RELEVANT REPRESENTATION OF EBBSFLEET DEVELOPMENT CORPORATION (EDC) IN RESPONSE TO LONDON RESORT DCO APPLICATION – 31 MARCH 2021

Executive Summary

Drawing Reference  
**LR-PL-WSP-DCP-2.12.5**

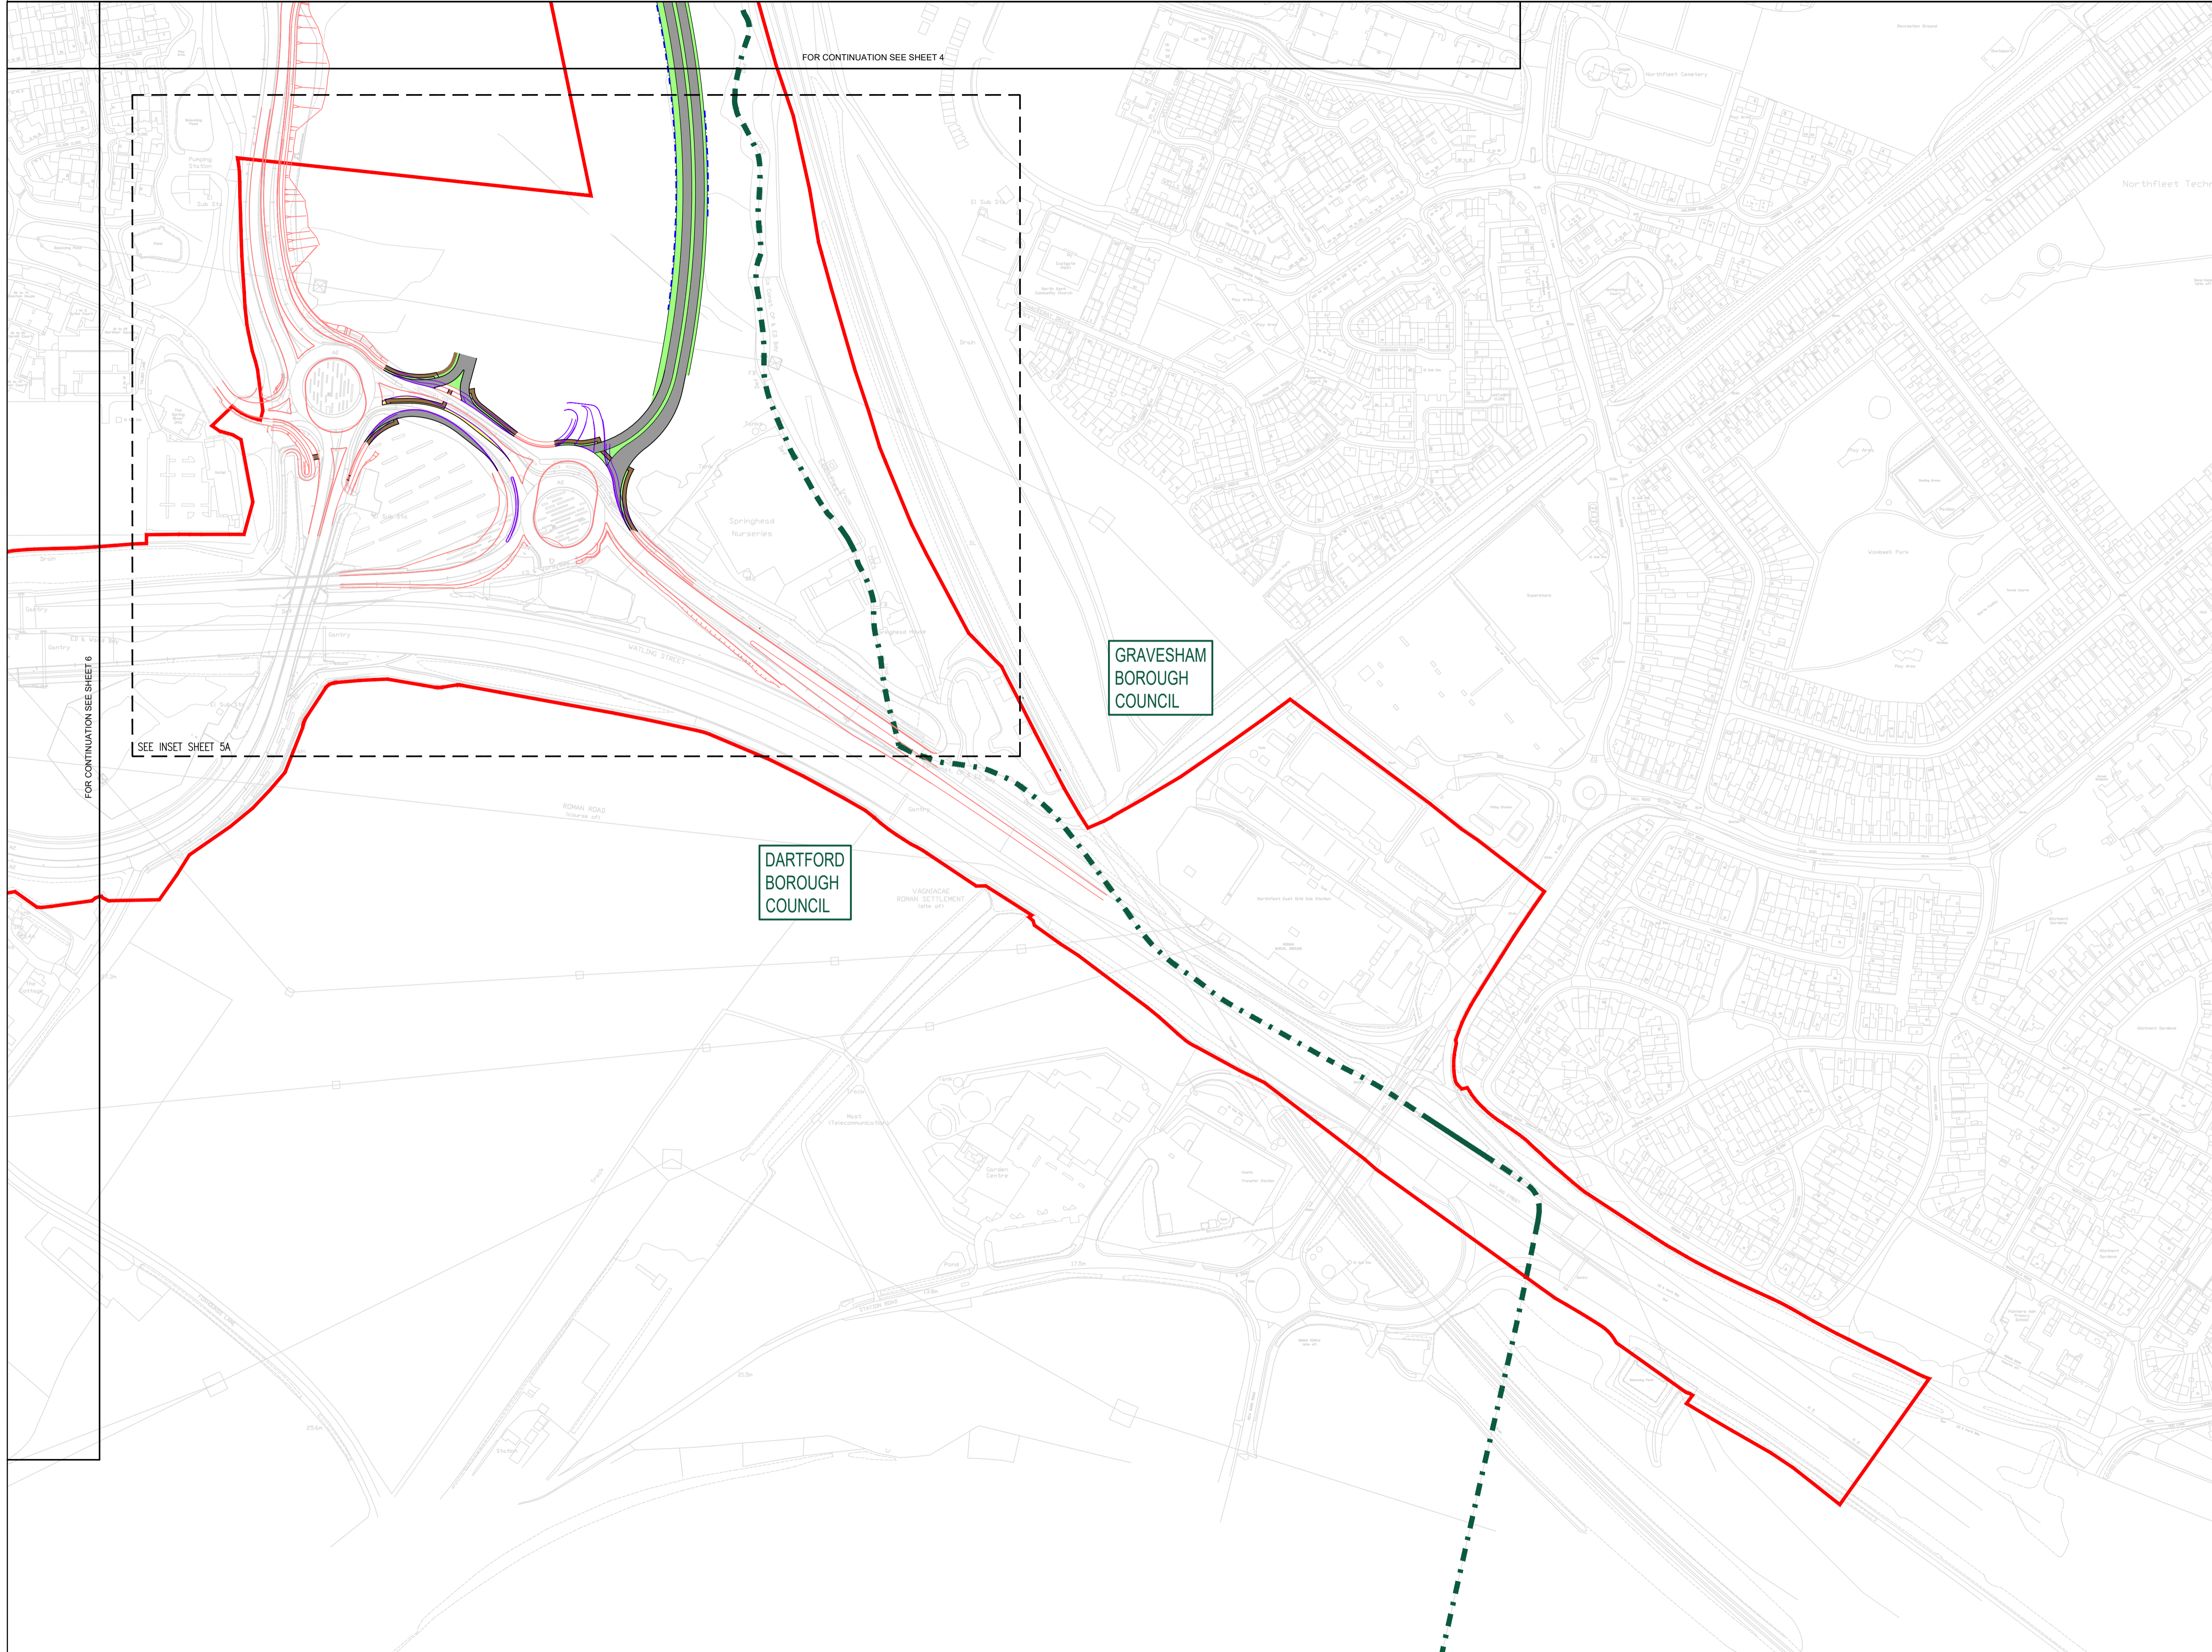
- 4.24. The DCO application incorporates an alternative access arrangement to Car Park D as part of constructing the proposed Resort Access Road. The principle of the proposed access appears suitable. However, there appears to be a conflict between the general arrangement and proposed contours and levels drawings provided for this access road. Clarification is sought as to the intention for the car park access road.

- 4.25. The placing of a roundabout east of the proposed access to Car Park D is confusing. LRCH identify this as being required to allow drivers, who have no intention of accessing the car park but who have inadvertently proceeded south along International Way, are able to return without need to enter the car park to turn around. Typically it would be expected for the roundabout to be placed west of the car park access to address this point and, as such, clarification in relation to this aspect of the proposals is sought.

- 4.26. The Resort Access Road will run along the area where the unbuilt HS1 car parking will be placed. The proposals also have an impact on both existing and un-built parking spaces within Car park D. However, the DCO application does not provide details of the number of existing and un-built parking spaces that will be lost and the commercial arrangements to secure this. Under the lease between EDC (as freeholder) and DfT (as lessee), EDC are required to re-provide any built car parking spaces and unbuilt car parking capacity for the HS1 station where this capacity is lost as a result of development. LRCH are aware of this requirement and EDC requires suitable assurances from LRCH to ensure that these lease obligations are not breached.

Ref. 6.3.3.2

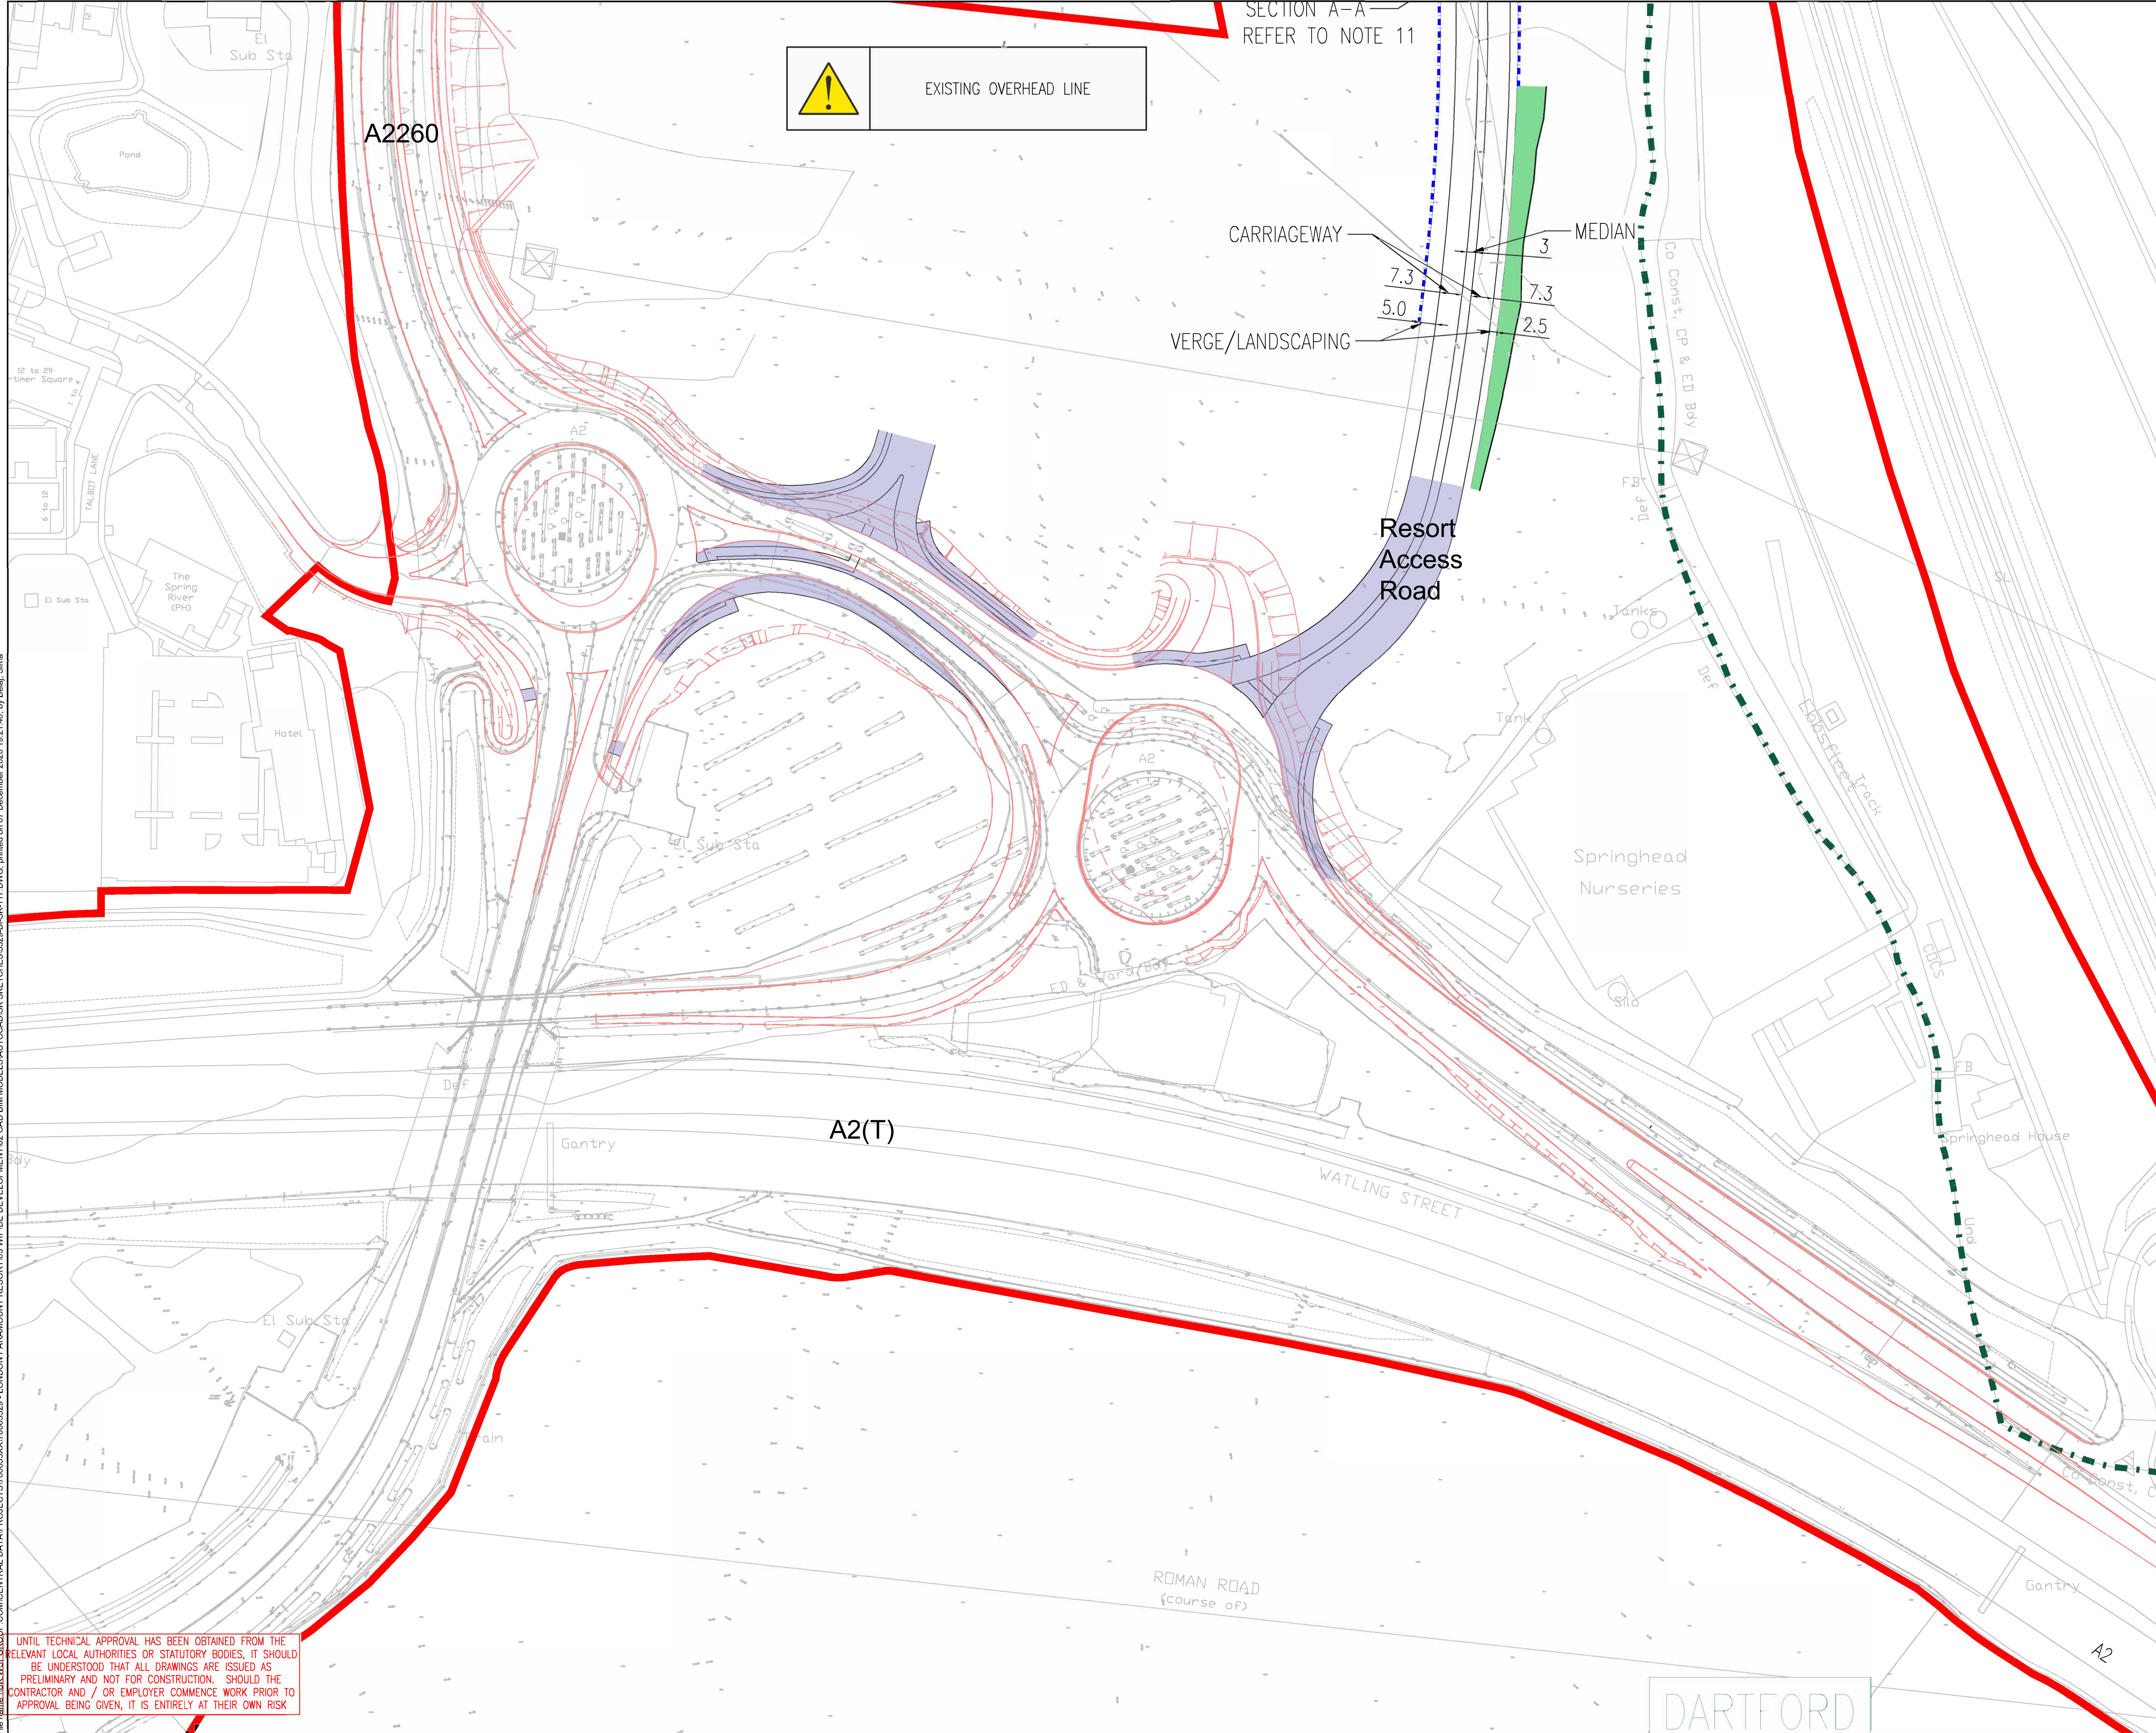
- 4.20. The traffic modelling undertaken for the A2 Ebbsfleet junction and the access to Station Quarter South (SQS) is inconsistent with the proposed design arrangements presented in the scheme drawings included in the Transport Assessment. It is therefore unclear as to the design arrangements that are intended for the junction. The scheme drawings show very little detail in relation to stop lines, signal heads or lane arrangements. It is only from sections of the Transport Assessment that we were able to establish that the access to SQS would be signal controlled. As a consequence, it is not possible to confirm that the design and appraisal of the new junction is appropriate and more specifically what impact it has on EDC's own plans for development.

- 4.21. EDC require clarification on the design arrangements proposed for the A2 junction, including access to SQS, and that evidence is supplied to show the accompanying operational appraisal is consistent with the design proposed. This includes stop lines, signal heads and lane arrangements to be shown on the access drawings as a minimum, as well as details in relation to the proposed phasing and staging arrangements proposed, including those for the access into SQS.

- 4.22. The DCO application states that an allowance for the Ebbsfleet Central scheme has been made in the appraisal for the A2 and SQS junctions. However, there is no data provided in the assessment or associated appraisal documents to explain the total trip forecasts for the scheme nor is there evidence to show this is included within the junction capacity assessments completed. This information is required.
